Current Zoning: N1-A (Neighborhood 1-A)
Proposed Zoning: N2-B(CD) (Neighborhood 2-B, Conditional)

Approximately 7.17 acres located on the south side of York Road and west side of Youngblood Road.

The petition proposes to allow an age restricted multifamily stacked development with up to 160 dwelling units on a vacant parcel in the Steele Creek community.

JOB NO. 62387
 SHEET NO. RZ-1

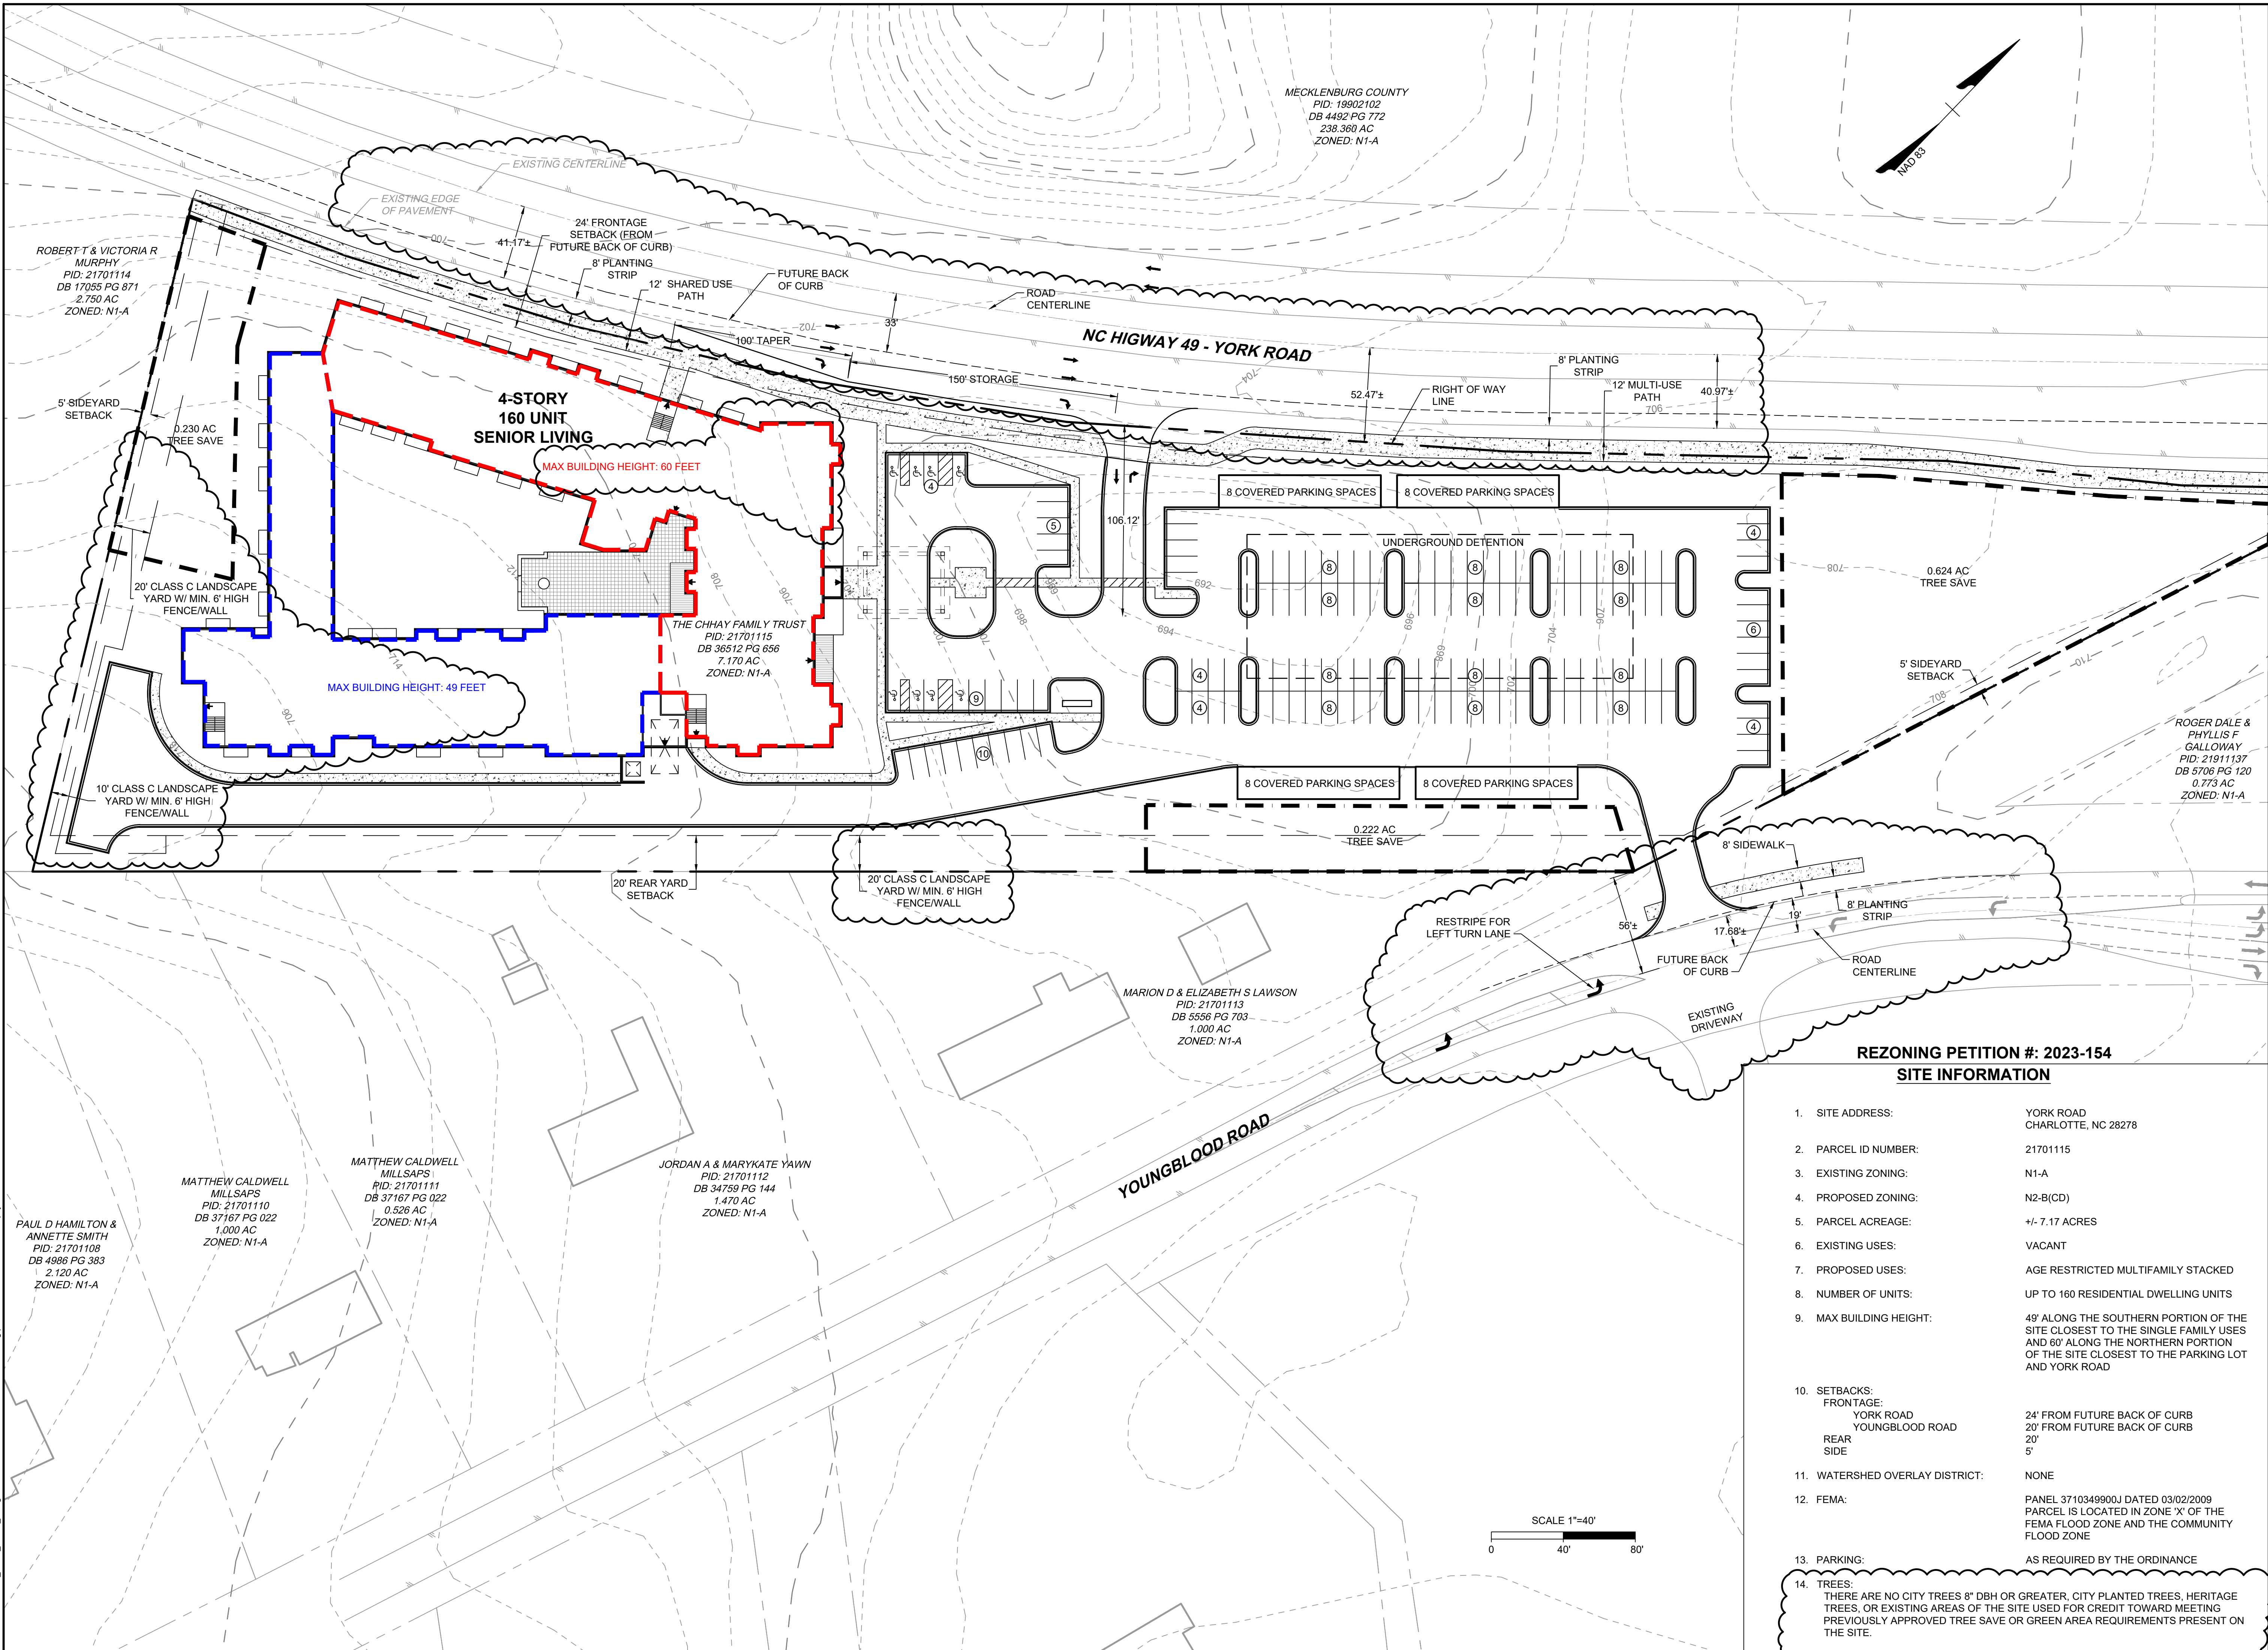
1. ~~Commit to a 25' Class B buffer with opaque fence where adjacent to N1 zoning and place type.~~
ADDRESSED

2. ~~Provide a tree survey showing all city trees 8" DBH or greater and all planted city trees, all existing heritage trees on site, and any existing areas of the site used for credit toward meeting previously approved tree save or green area requirements.~~ ADDRESSED
3. ~~Verify that tree save areas are contiguous.~~ ADDRESSED

4. ~~Label and dimension the curb and gutter from the centerline for each road on the site plan.~~
ADDRESSED
5. ~~Label and dimension the right of way from the road centerline.~~ ADDRESSED

6. ~~In coordination with NCDOT, revise site plan and conditional note(s) to show the existing driveway on the east side of Youngblood Road. Align the sites entrance along the centerline of the existing driveway.~~ ADDRESSED

7. ~~Revise site plan and conditional note(s) to commit to restriping a left turn lane into the site off of Youngblood Road.~~ ADDRESSED
8. ~~Revise site plan and conditional note(s) to construct 8-foot planting strips and 12-foot multi-use paths on York Road and Youngblood Road. The site plan shall label and dimension both items from the back of curb and gutter or edge of pavement. Add conditional note stating the entire facility must be outside of the right of way and within a public access easement. Add conditional note committing to construction and maintenance of the 12-foot multi-use paths on York Road and Youngblood Road. Revise site plan to show all sidewalk outside of the NCDOT right of way and inside a public access easement.~~ ADDRESSED
